KITTITAS COUNTY COMMUNITY DEVELOPMENT SERVICES

Subject: Zipperer Short Plat Final (SPF-21-00002) – Staff Review and Request for Additional Information

**ZIPPERER SHORT PLAT, SP-20-00005
 SPF-21-00002**

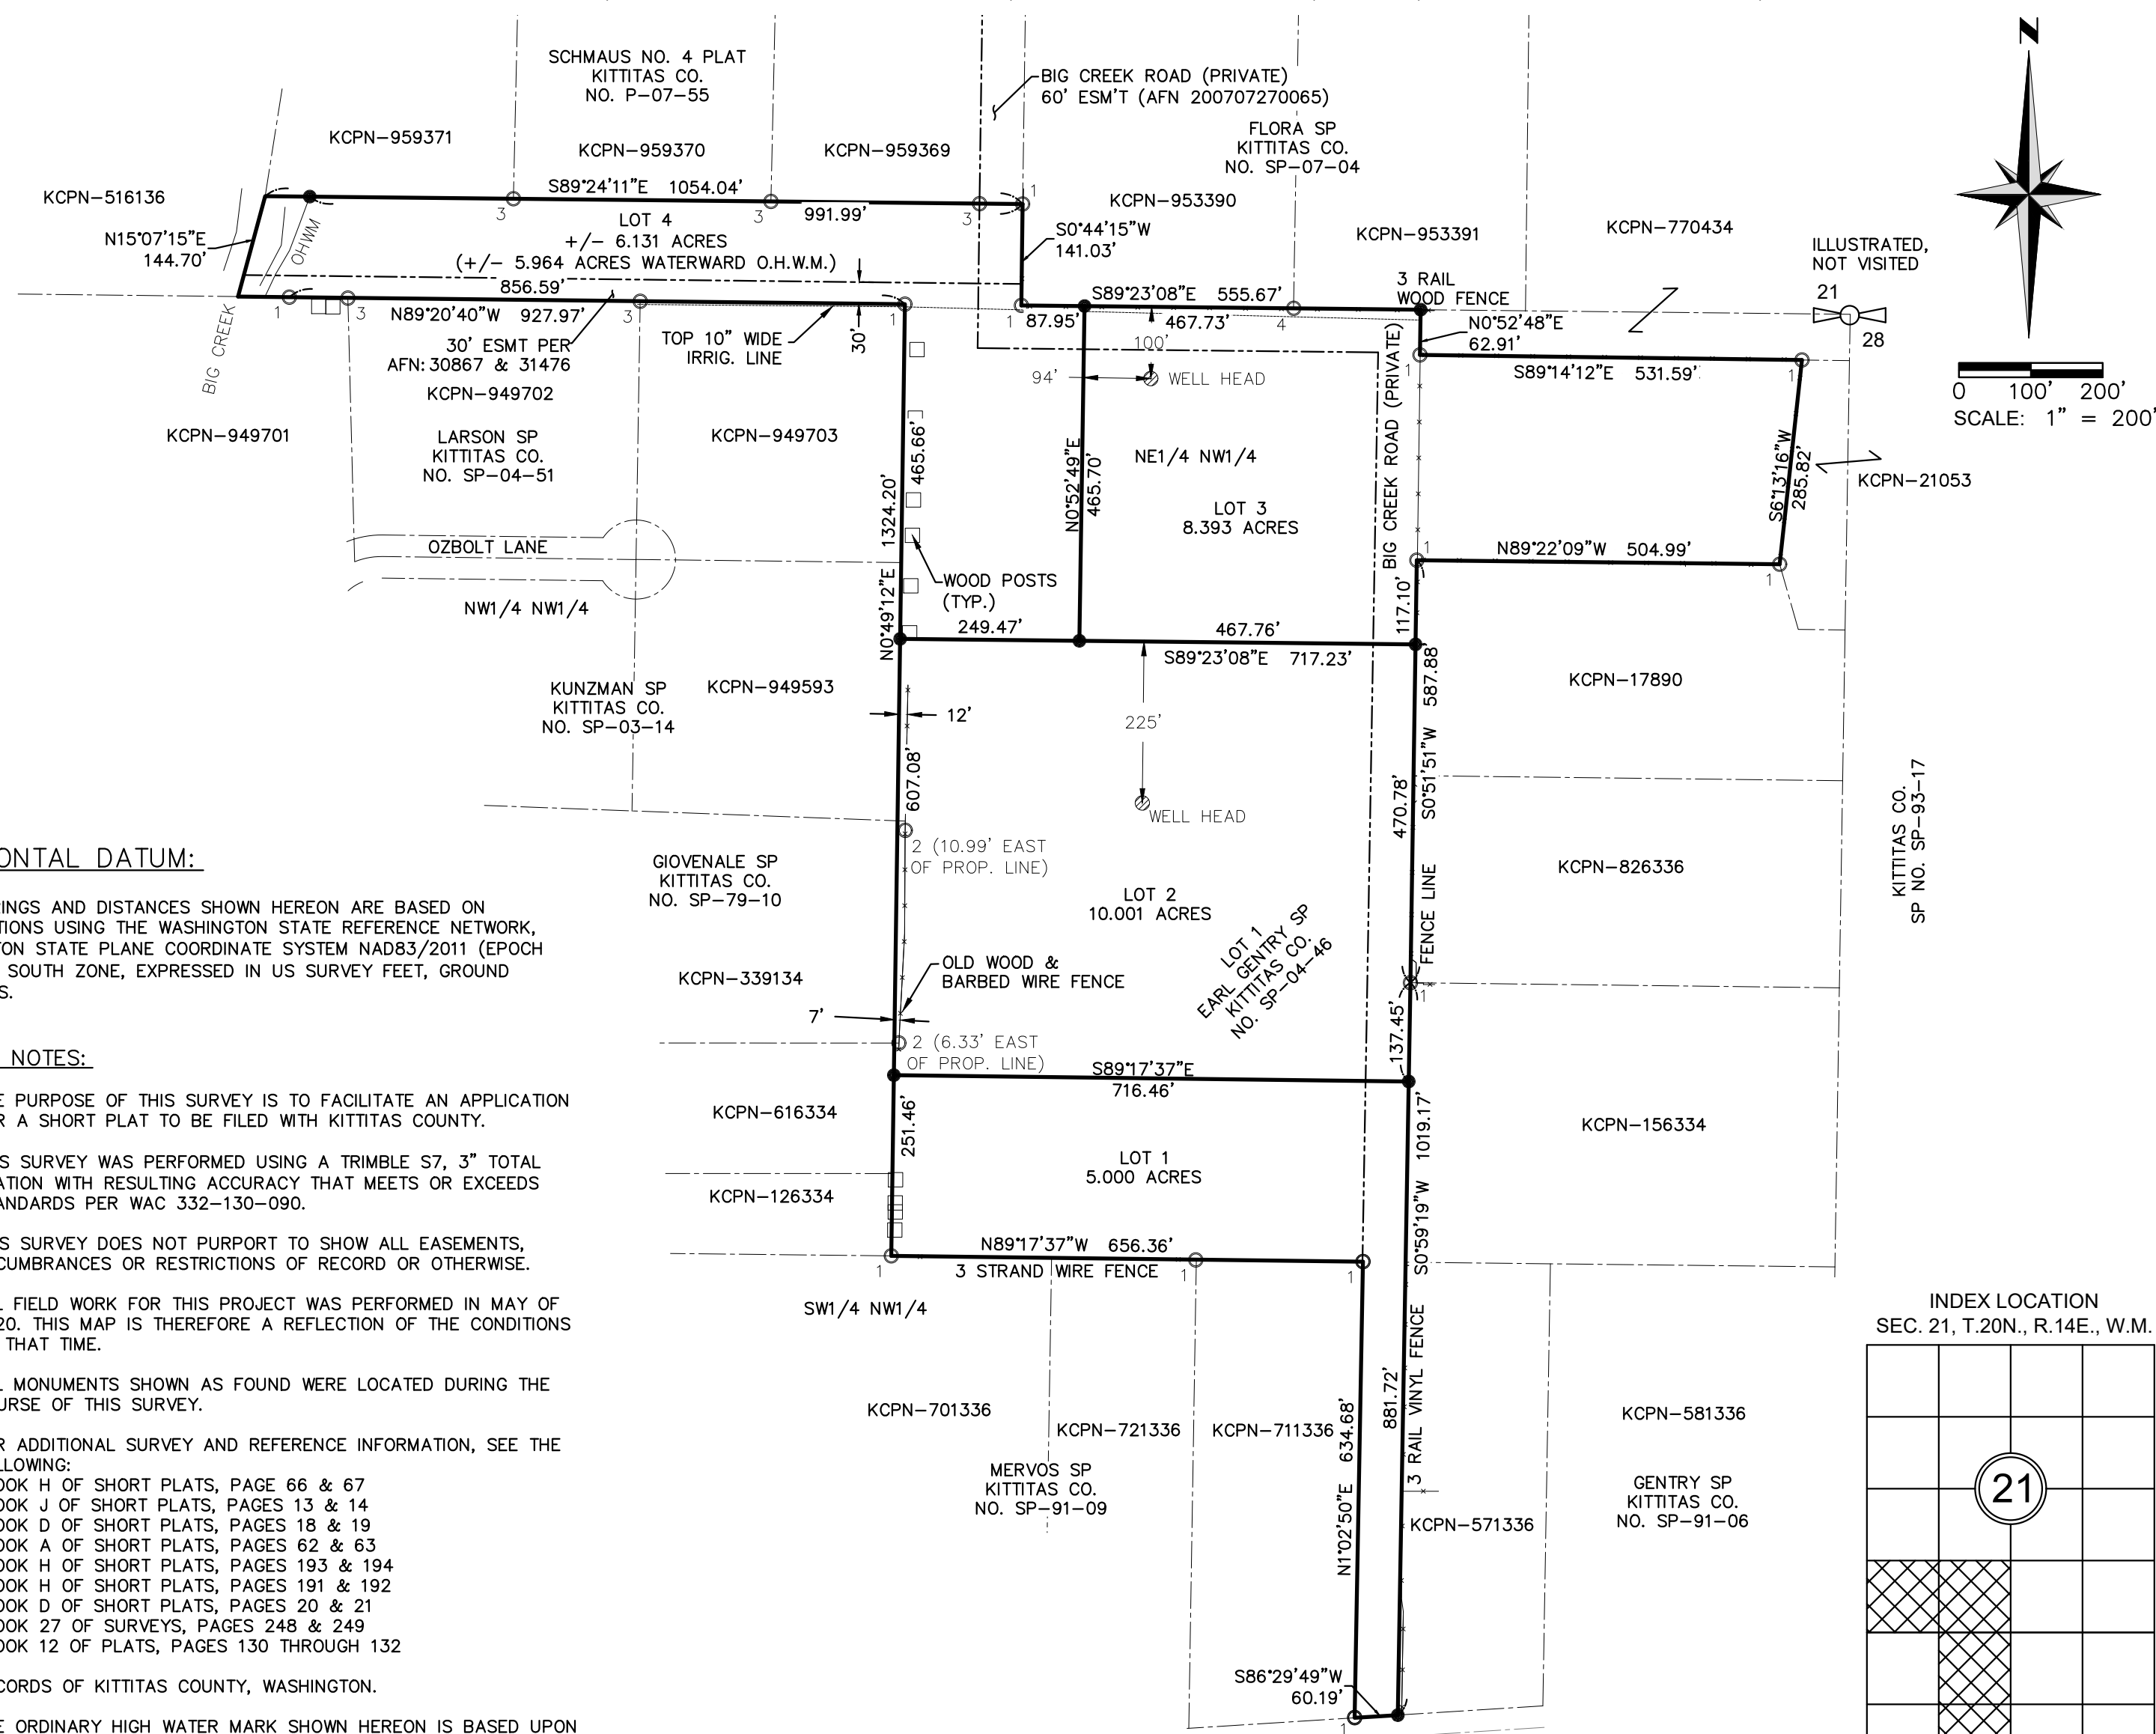
- The final short plat number “SPF-21-00002” shall also be present on the face of the plat and located directly above or below the SP-20-00005 already shown.

ZIPPERER SHORT PLAT, SP-20-00005
A PORTION OF SECTIONS 21 & 28, TOWNSHIP 20 NORTH, RANGE 14 EAST, W.M., KITTITAS COUNTY, WASHINGTON

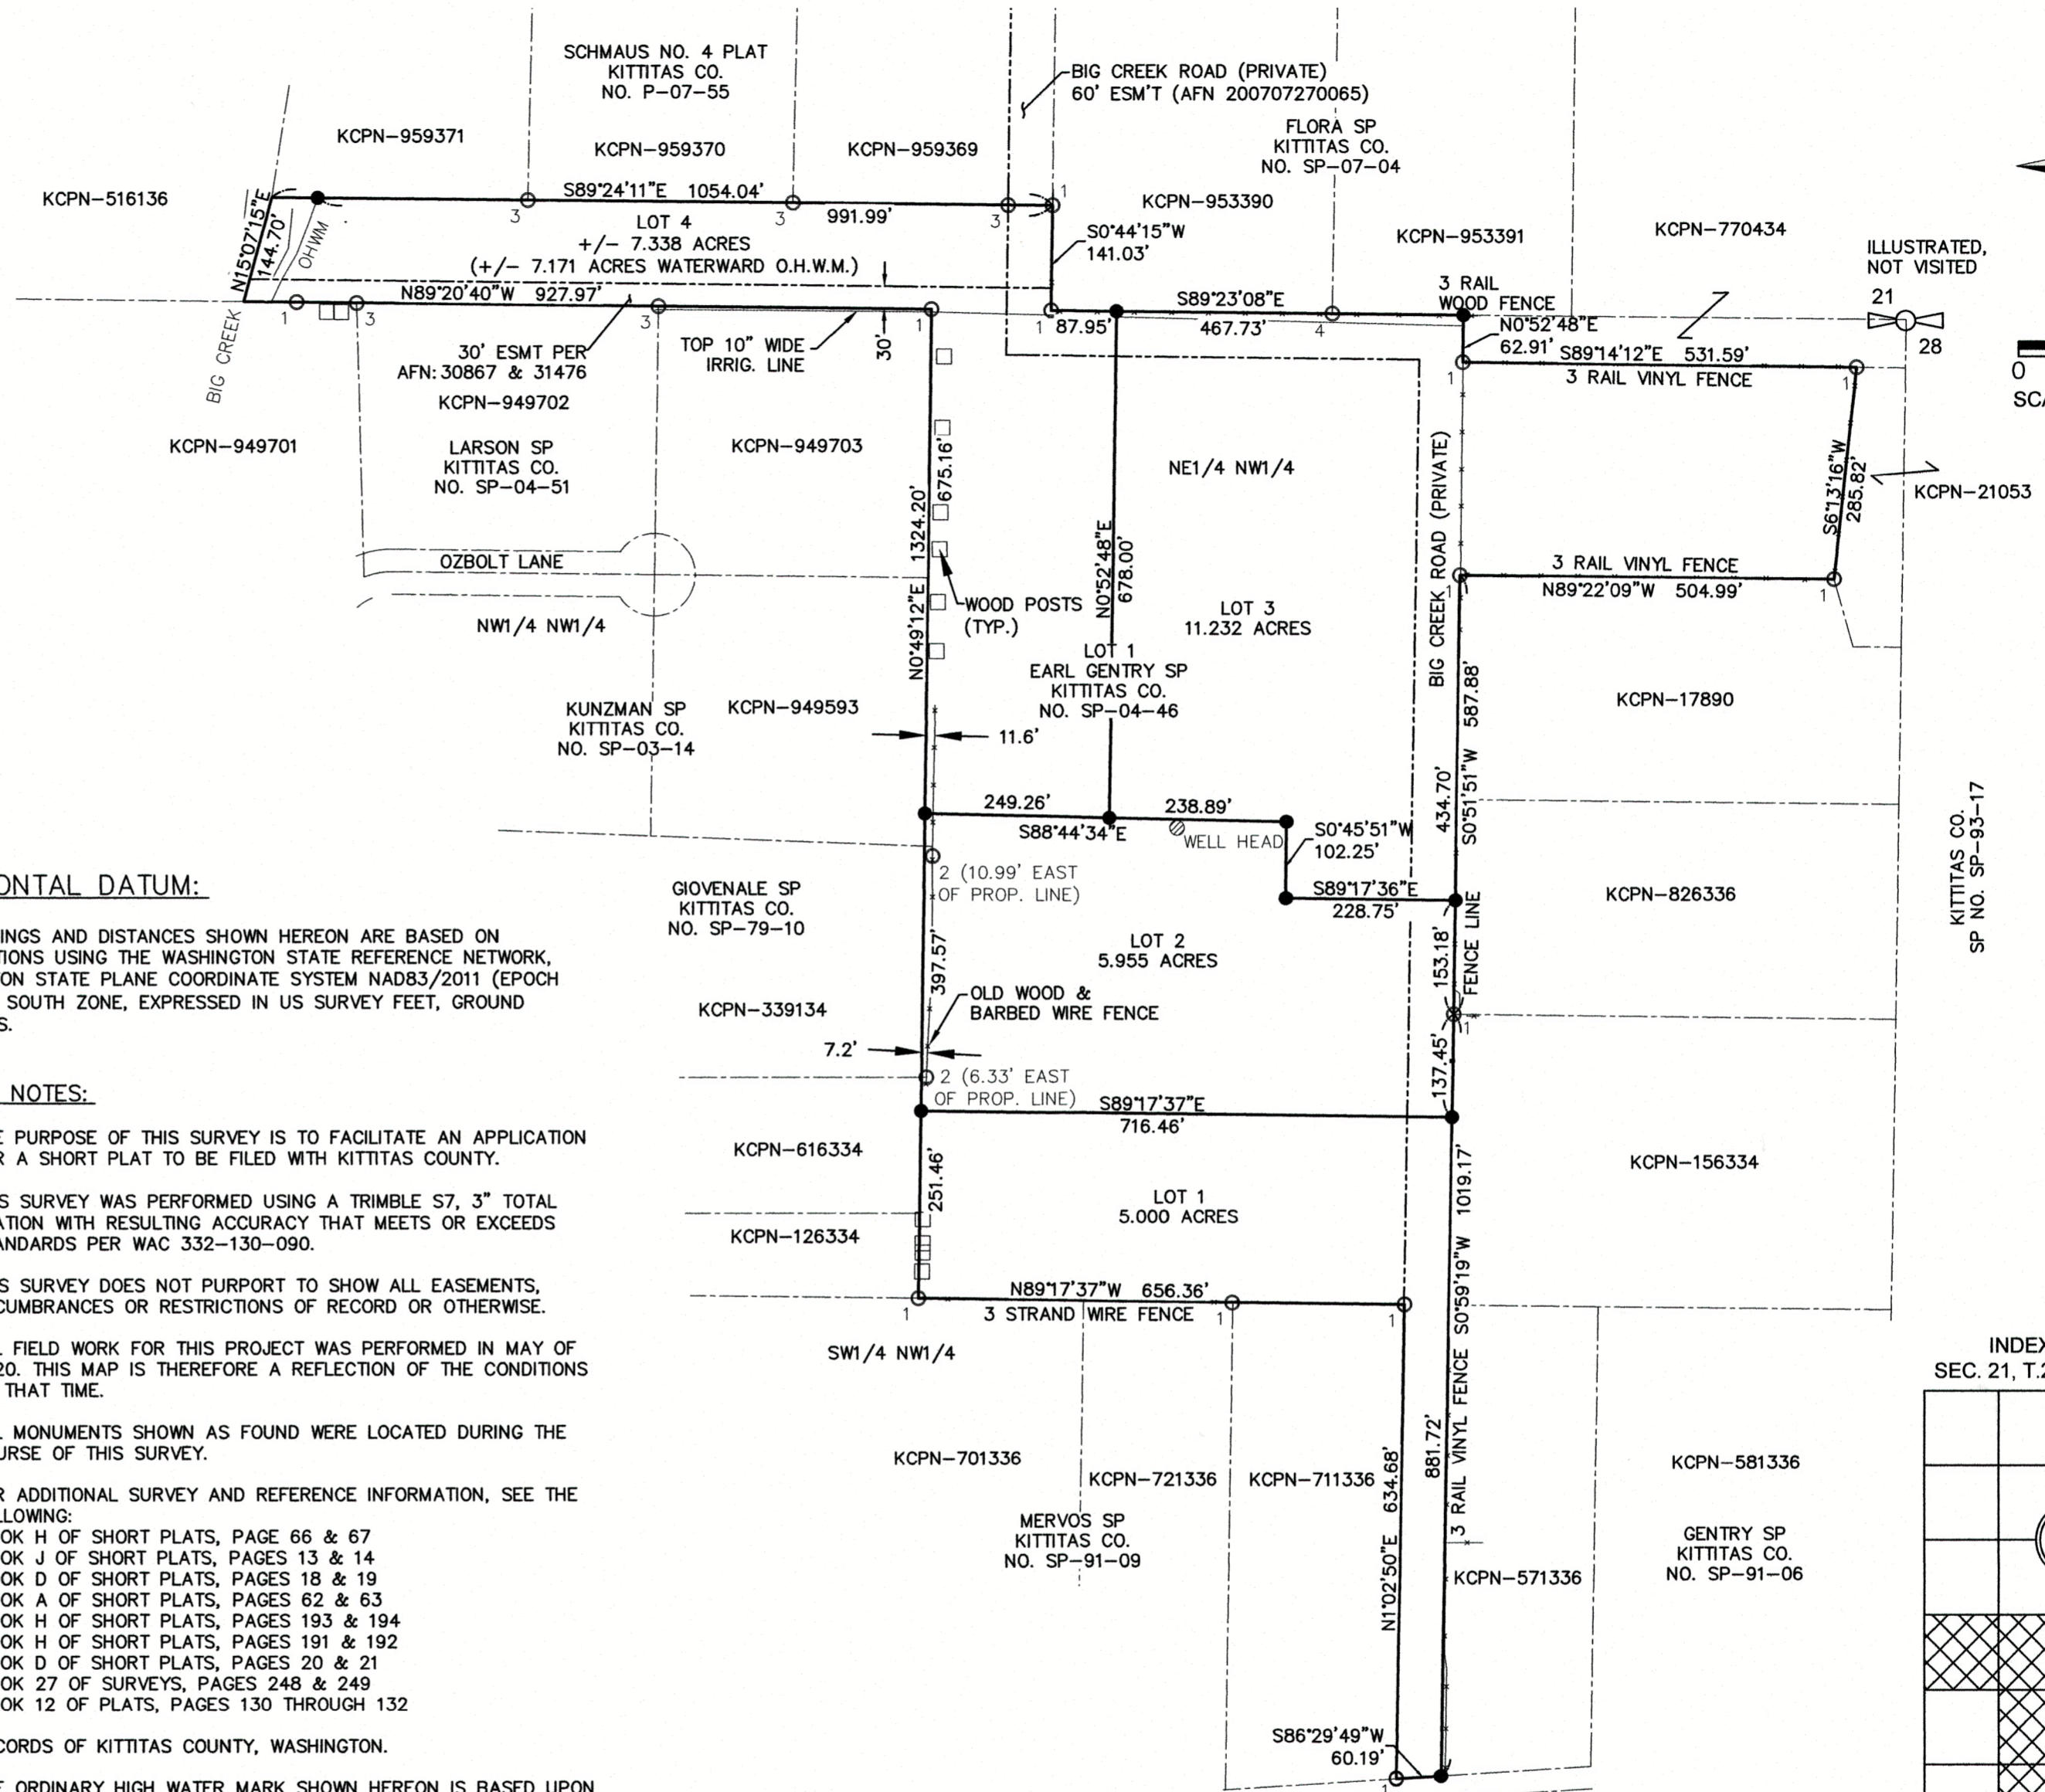
- Adequate water rights documentation needed.
- Proof of adequate water supply requested.
- Well’s must meet the 50’ setback requirement and site plan must show proposed drilled wells.
